From: [REDACTED]
To: [A38 Derby Junctions](#)
Cc: [REDACTED]
Subject: Re: [External] A38 Derby Junctions Project - My Reference number: 20022799
Date: 27 October 2019 21:18:17

Please find my **representation** in response to the information provided for Little Eaton junction :

Drawing Title  
FIGURE 2.7  
LITTLE EATON JUNCTION  
GENERAL ARRANGEMENT

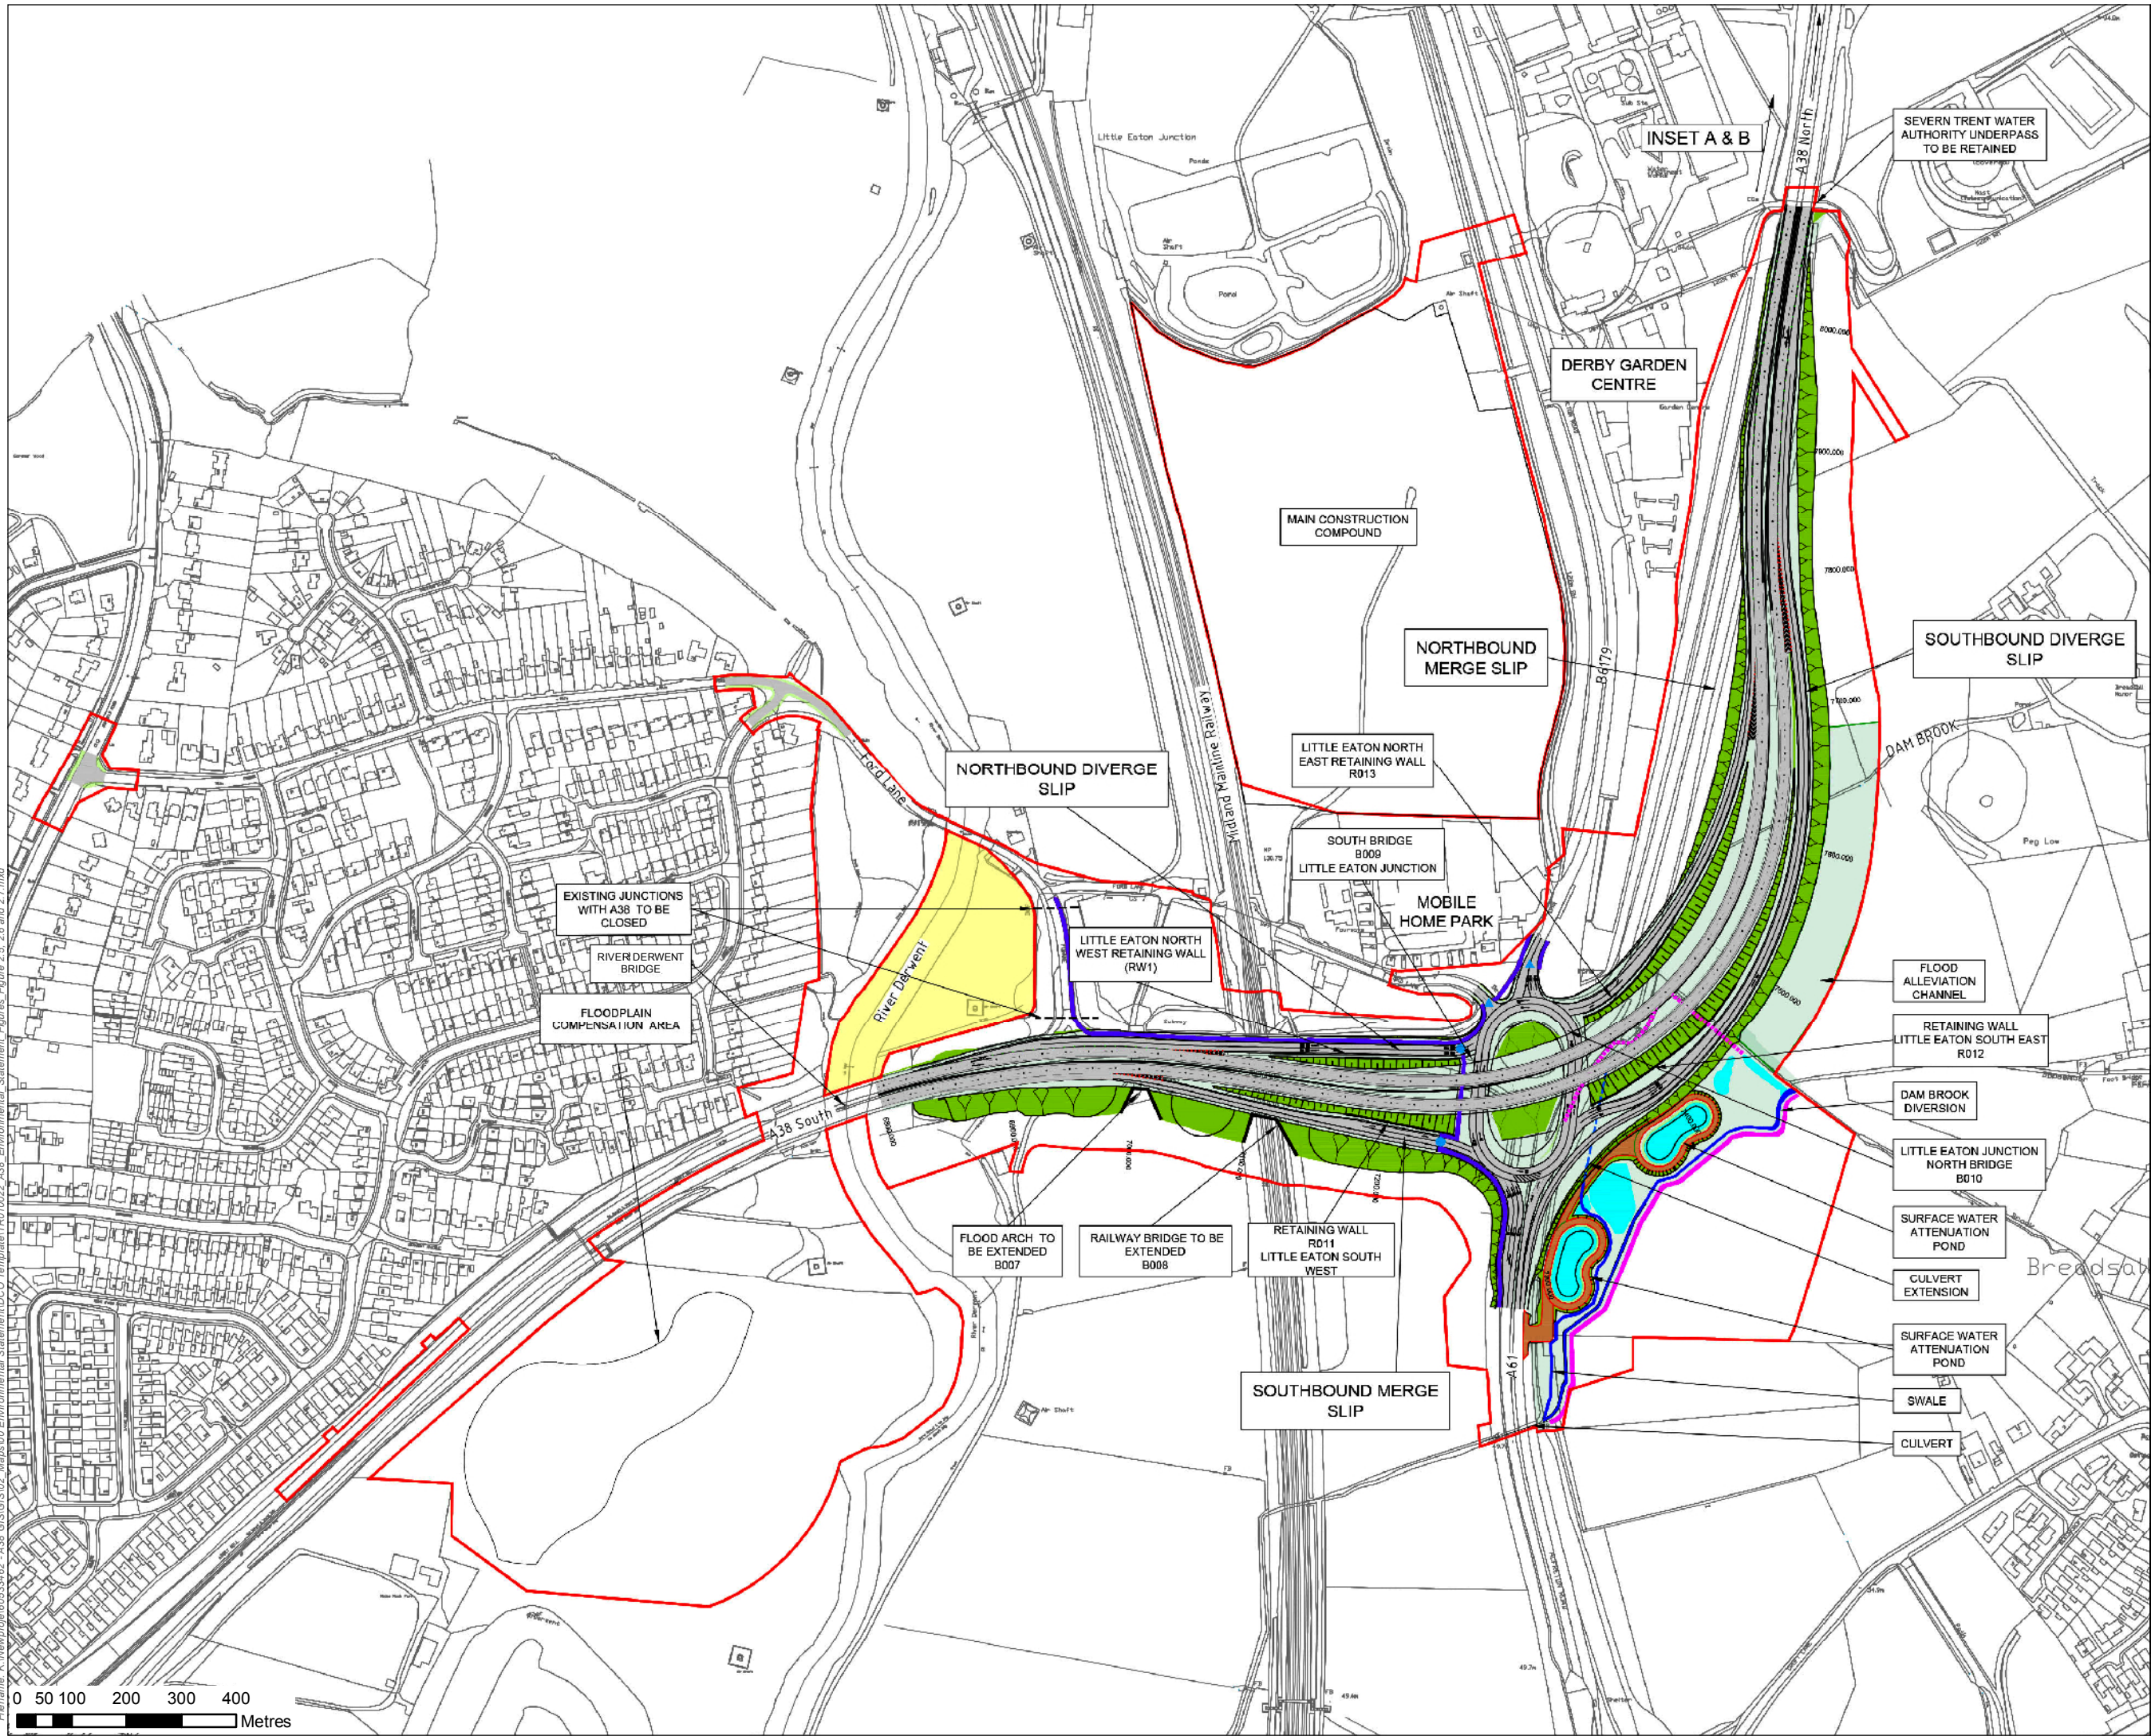
2) I agree with the current extent of the noise barrier subject to review of the final "issued for construction" drawings and consultation on the actual specification and make up of said 2.5 m high barrier

3) I believe the landscaping by the balancing ponds by the southbound off slip merge with the A61 needs to be widened

4) I wish to see many more evergreen trees planted throughout the landscape areas between the road and Breadsall. Whilst I understand the native species reasons in this instance when there is a considerable bank of native species adjacent to the road as planted by my father this should compensate.
